RIBBLE RIVERS TRUST

SUBJECT: Planning Application No. 3/2014/0183

Thank you for asking us for our comments with regard the planning application for Kirk Mill (number cited above).

1. Main Mill Complex
2. The Hive (Residential)
3. New Trail Head Centre
4. Cricket Pitch
5. Allotments

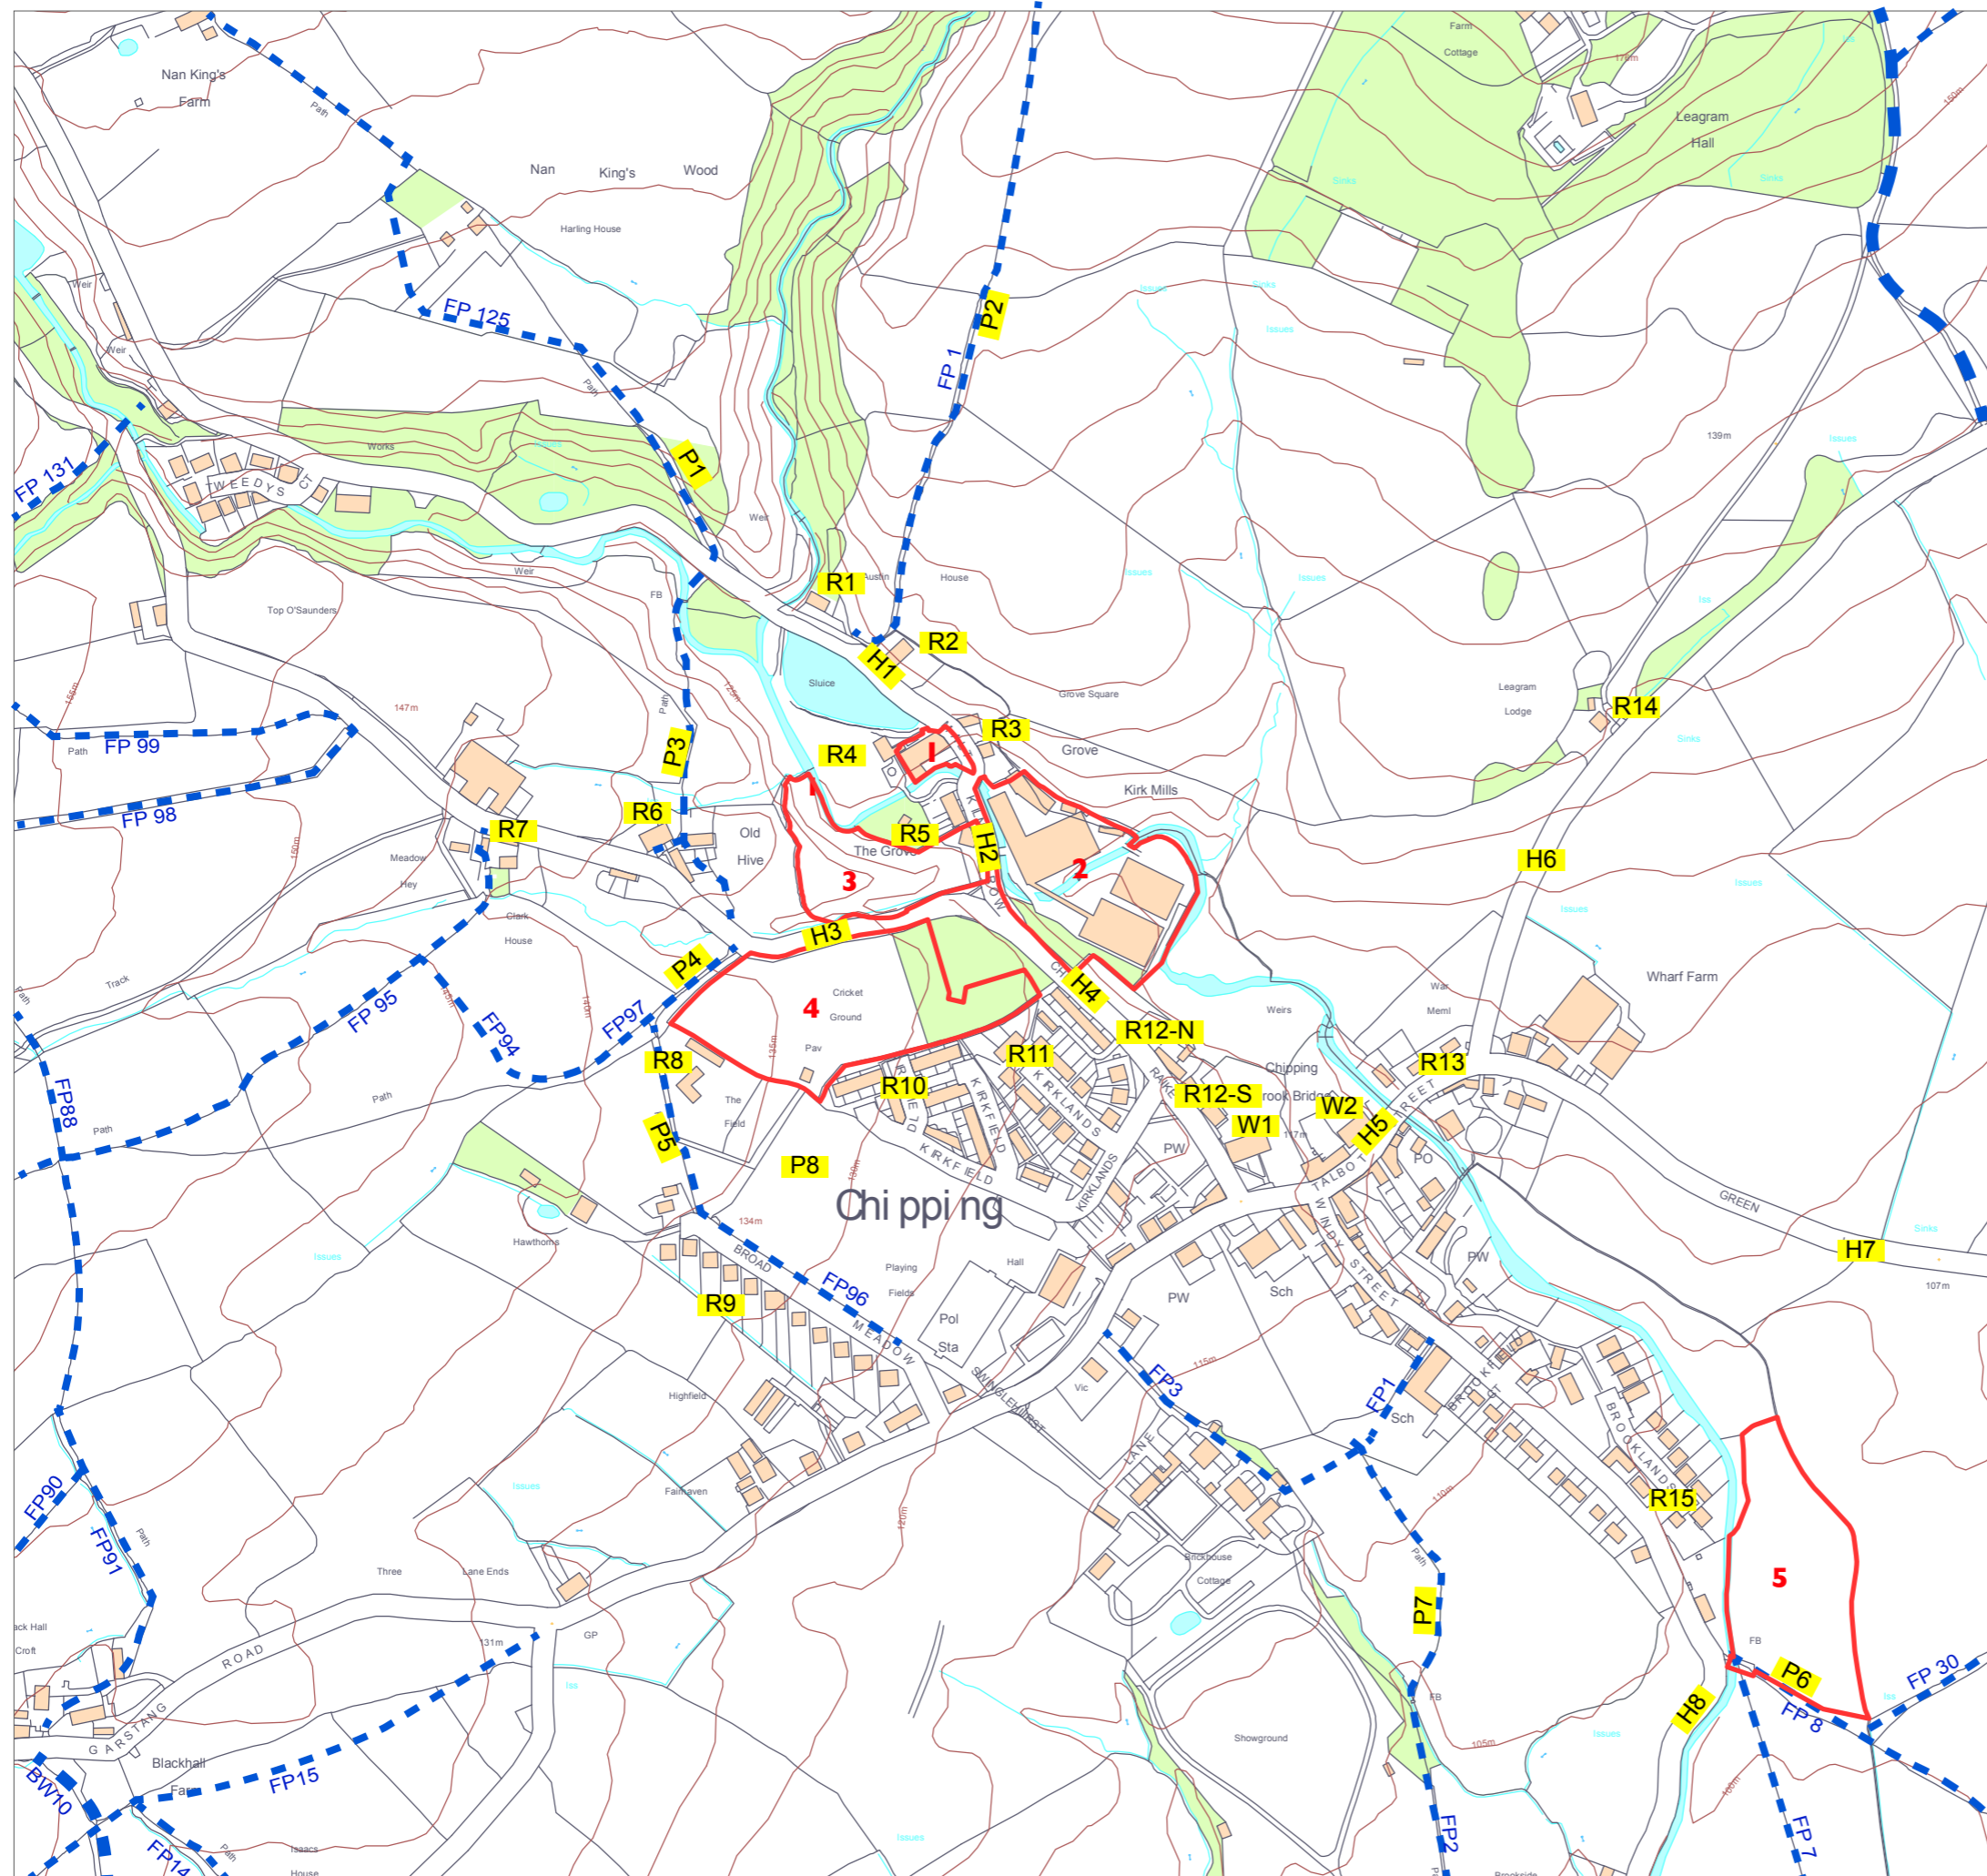
We note from the "Master Plan" document that the area to the North West of the main development is ear marked for riverside walk and allotments. We encourage the engagement of the public with rivers, and as such provision of a riverside walks is commendable. However converting this area to allotments is potentially damaging to the brook, and to the surrounding ecology. We would not wish to see this valuable wet woodland (a priority habitat) damaged. Allotment provision should be elsewhere.
